DESIGN RESPONSE

20009DA

104-116 REGENT STREET
REDFERN

09 JUN, 22

DRAWING SERIES
Design Analysis
DRAWING TITLE
Shadow Diagrams - 21 JUNE
2022.1

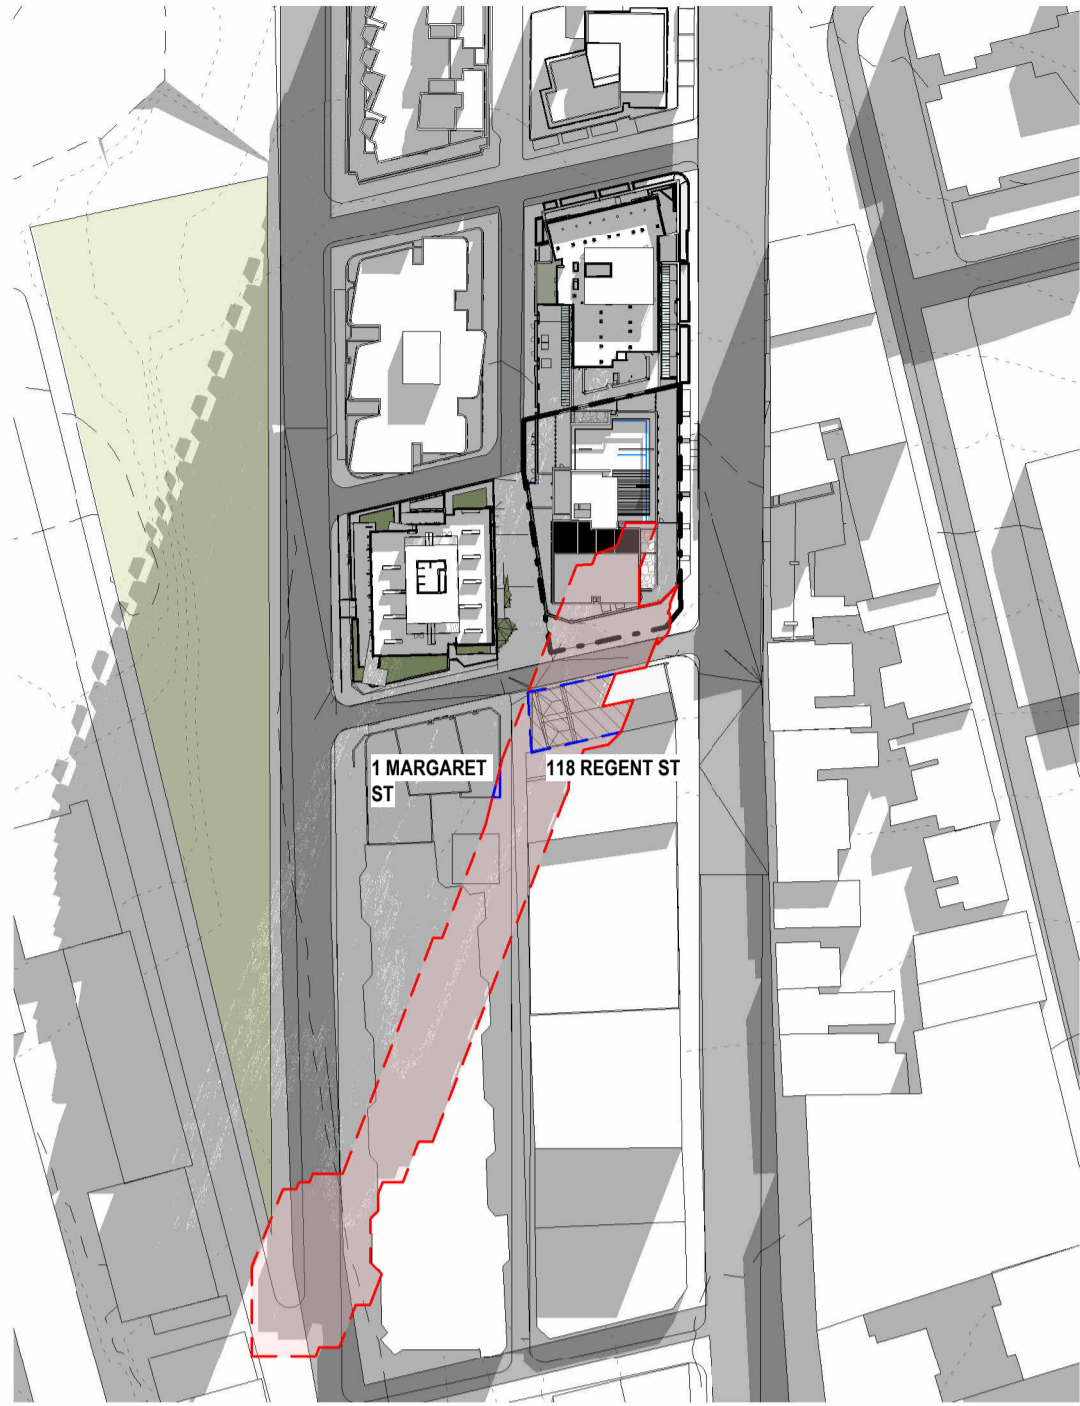
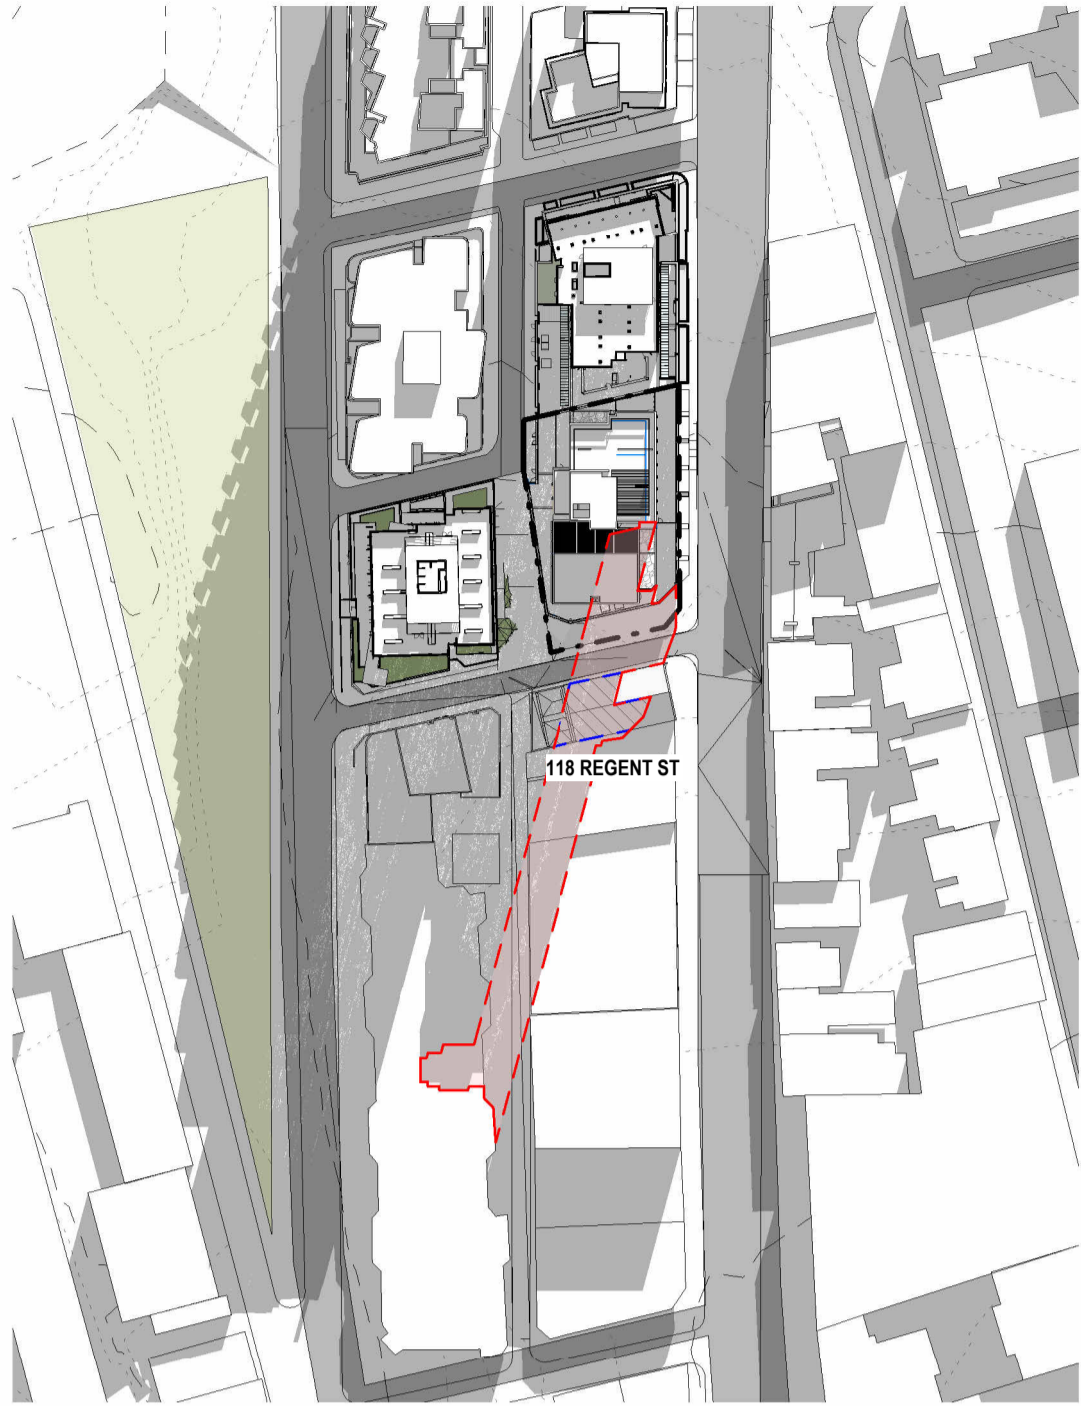
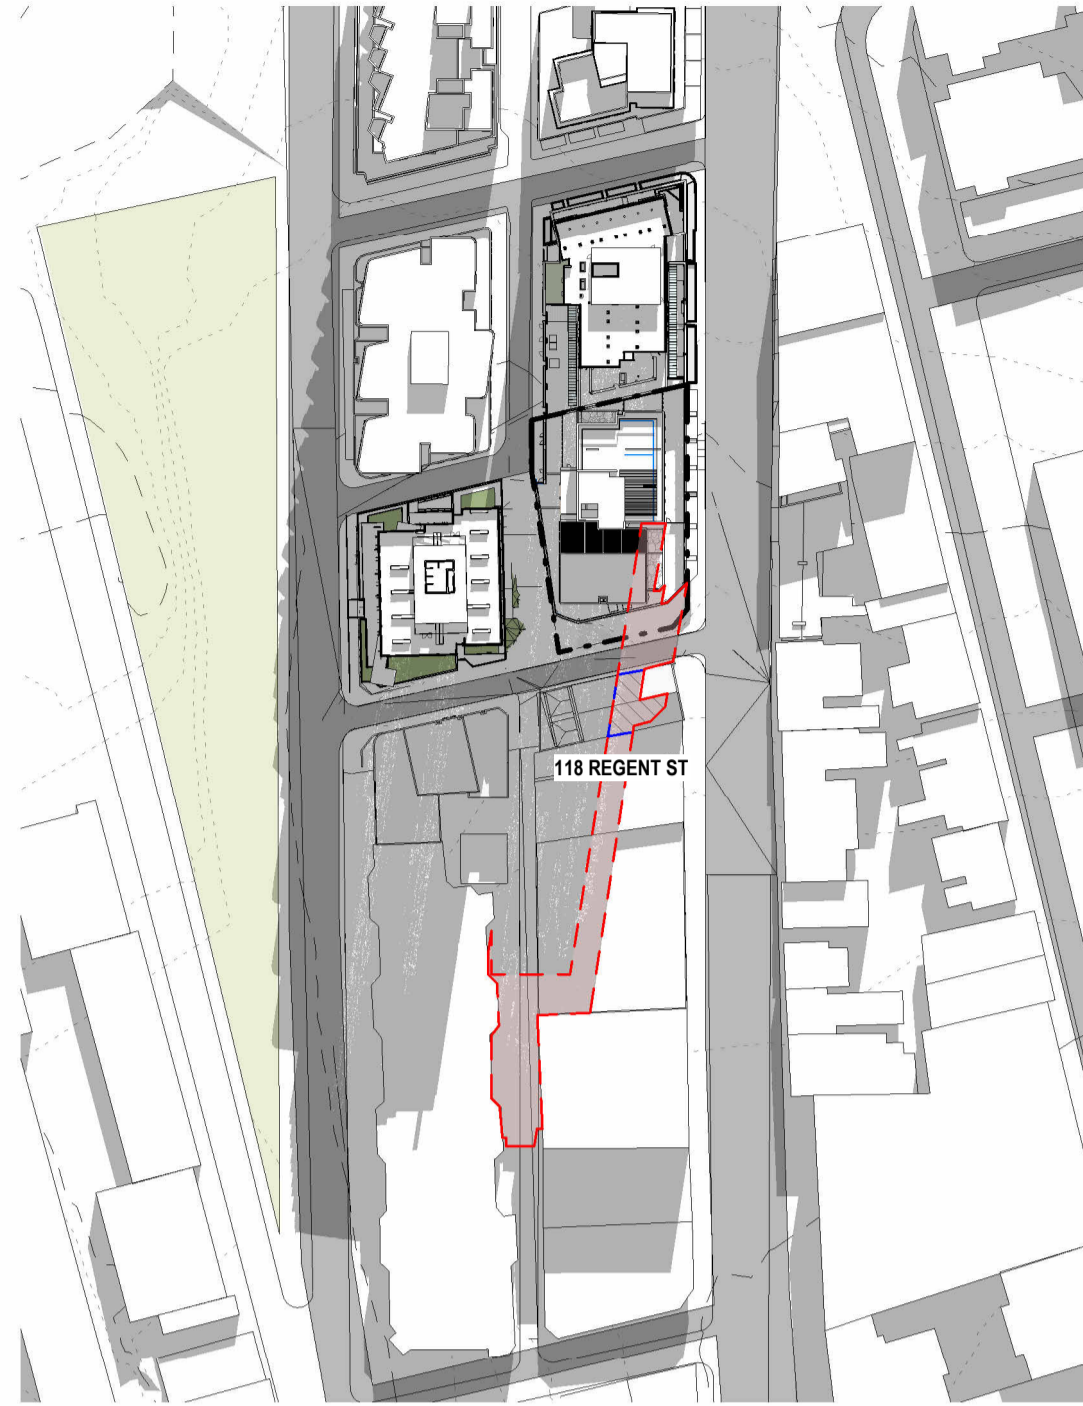
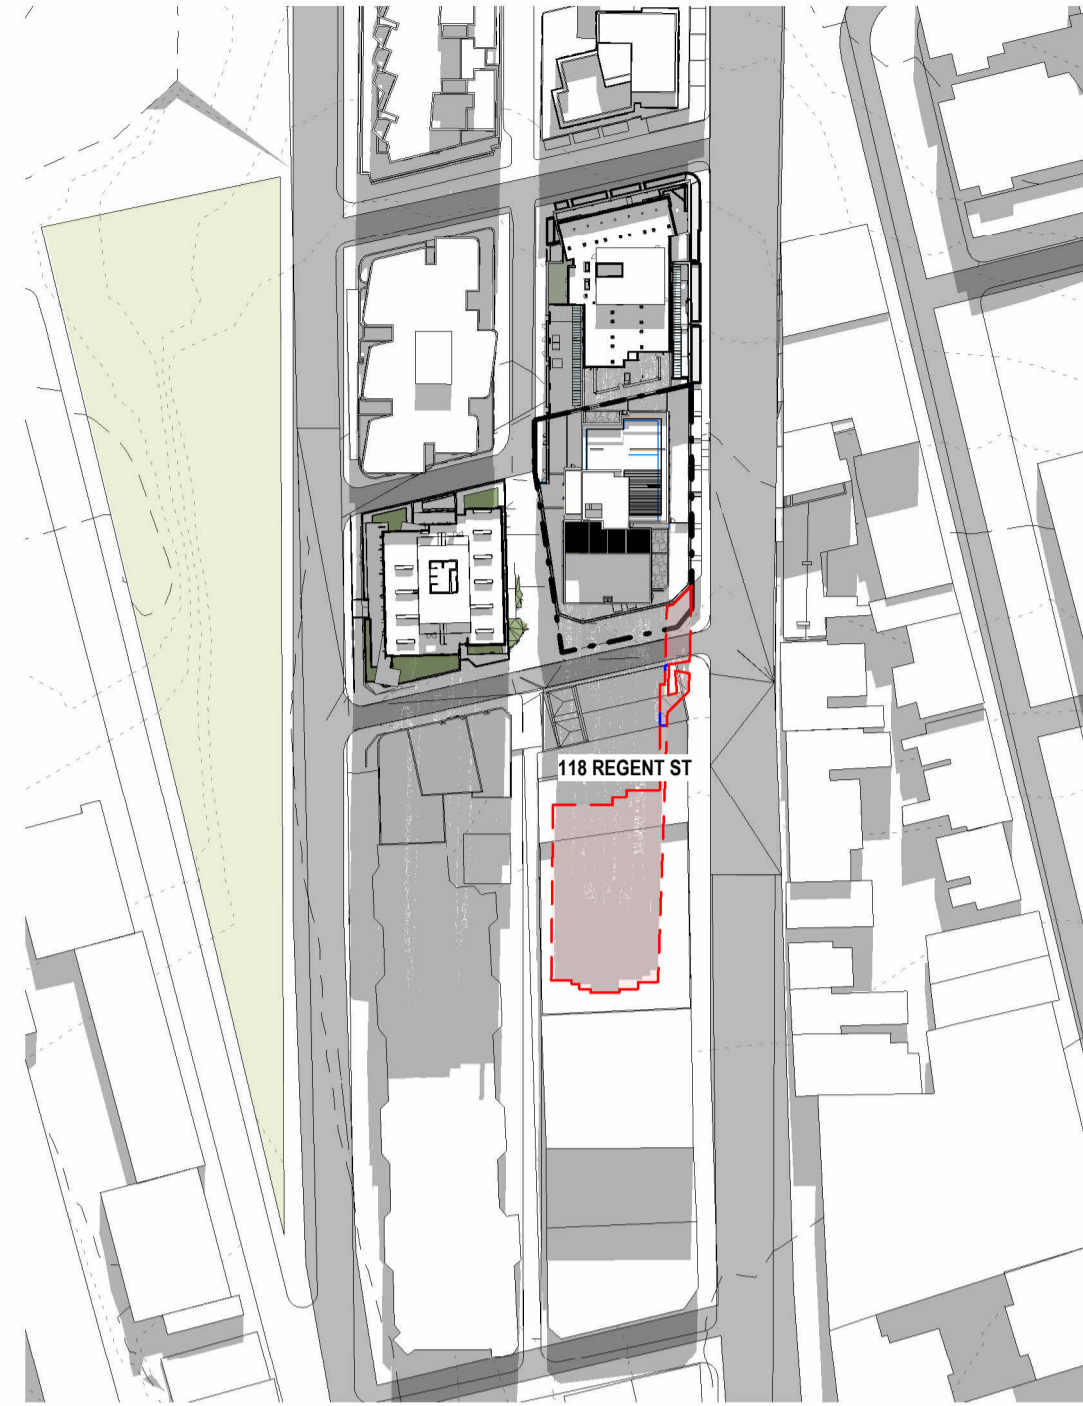
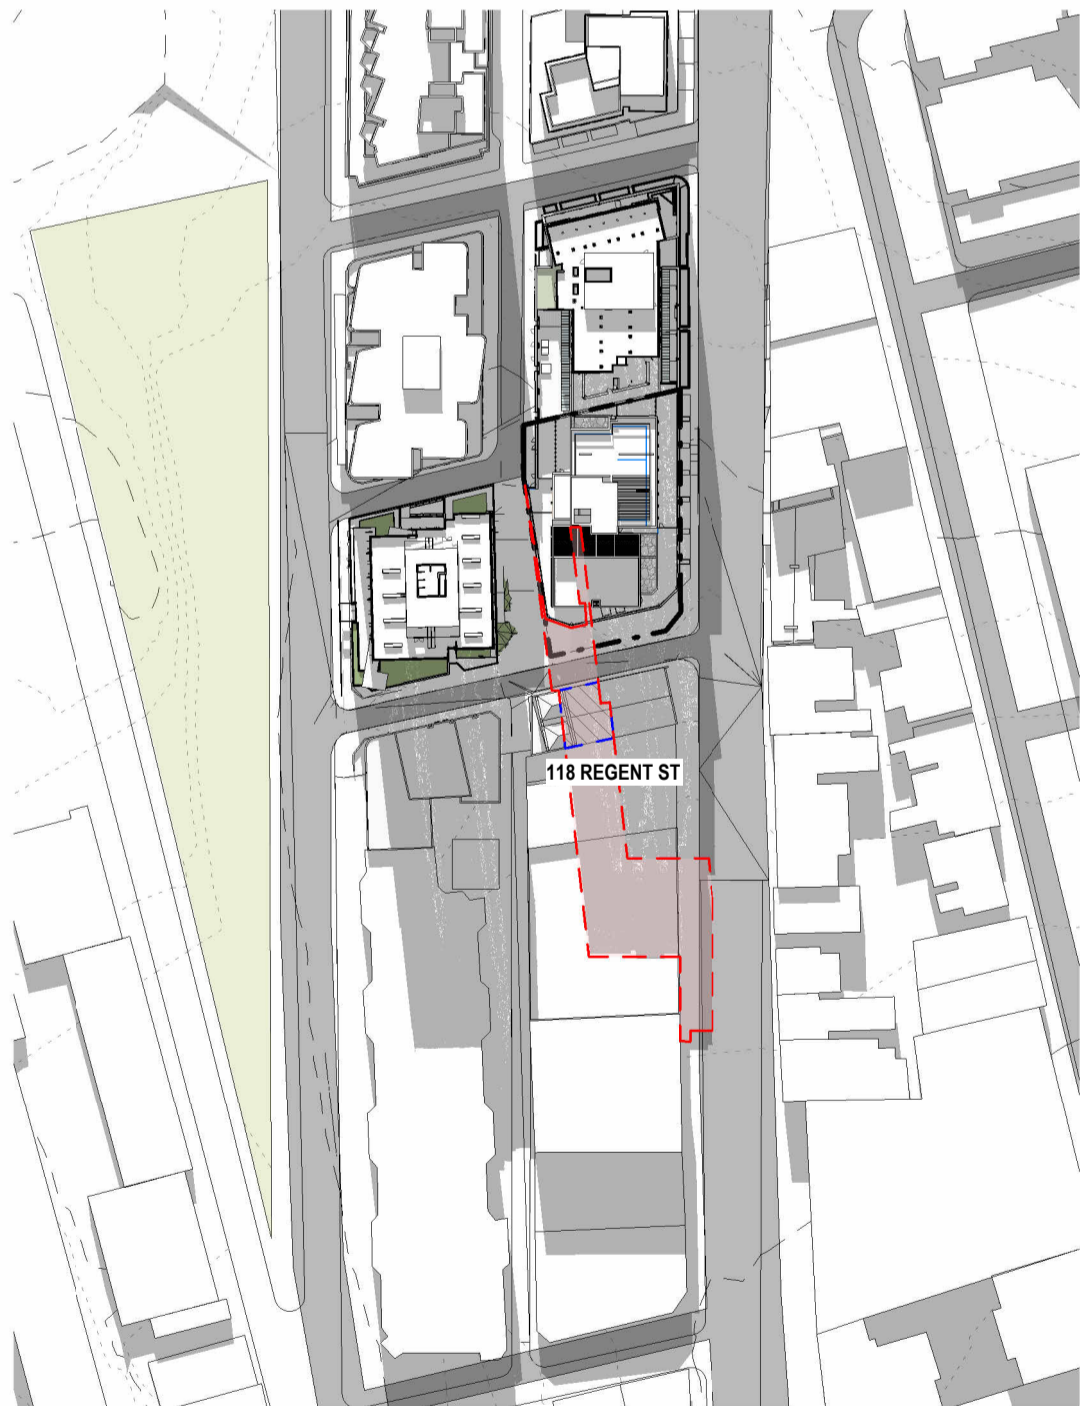
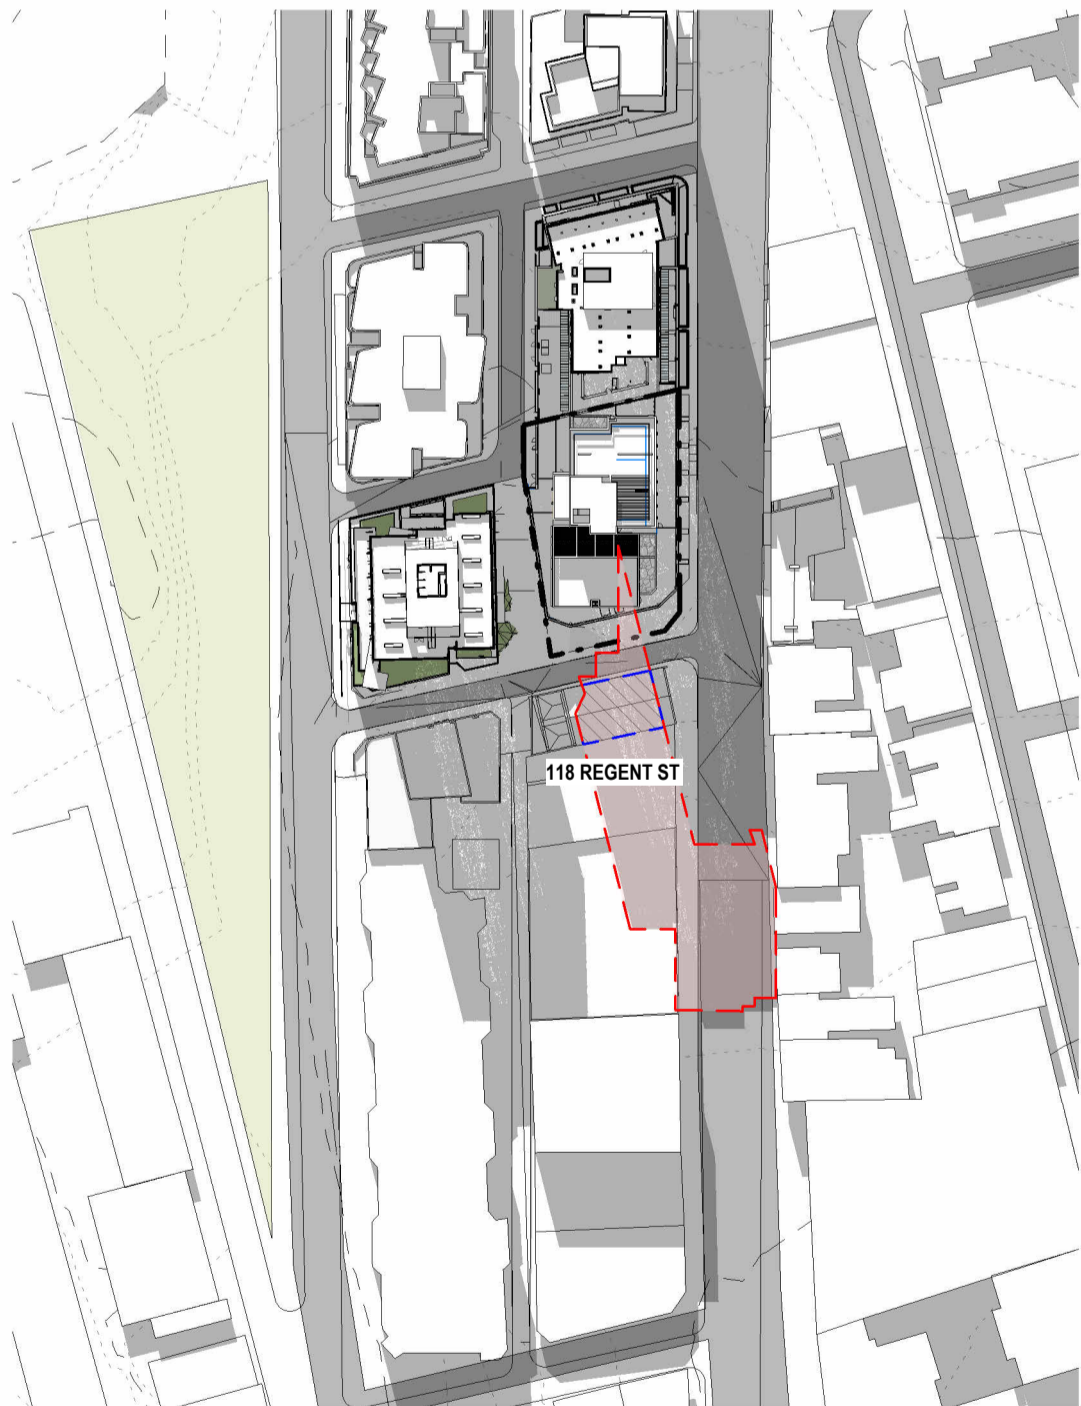
The overshadowing analysis confirms that the proposal would cast a large shadow over properties to the southwest, south and southeast in mid-winter. The analysis does not consider the specifics of any overshadowing on individual properties nor does it capture the full extent of the overshadowing impacts with cropped shadow plans omitting the full shadow extent.

The impact must be quantified, in terms of both the measurable criteria in the RCUDP controls, and any impacts justified of particular concern is the impact to 1 Margaret Street and the playing field at National Centre of Indigenous Excellence at 160-202 George Street.

Additional information, which quantifies resulting solar access, the overshadowing impact, and adequate justification is required for these sites in half hourly views from the sun.

Additional information of half hourly views provided with extended view to capture the south east shadowing. Refer architectural drawings DA 6.02 and DA 6.03 (refer appendix on pages 22 & 23). The proposed built form has been designed to avoid unacceptable shadow impacts to surrounding developments and public domain.

The shadow analysis of proposed development on 1 Margaret Street and 160-202 George Street offers the following assessment :

- Additional overshadowing from amended proposal has minimal impact on 1 Margaret Street , overshadows only small corner area on the south eastern corner outlined in blue (refer to figure15)
- Additional overshadowing from amended proposal overshadows a portion of the playing field at National Centre of Indigenous Excellence only between 2.30 -3.00pm
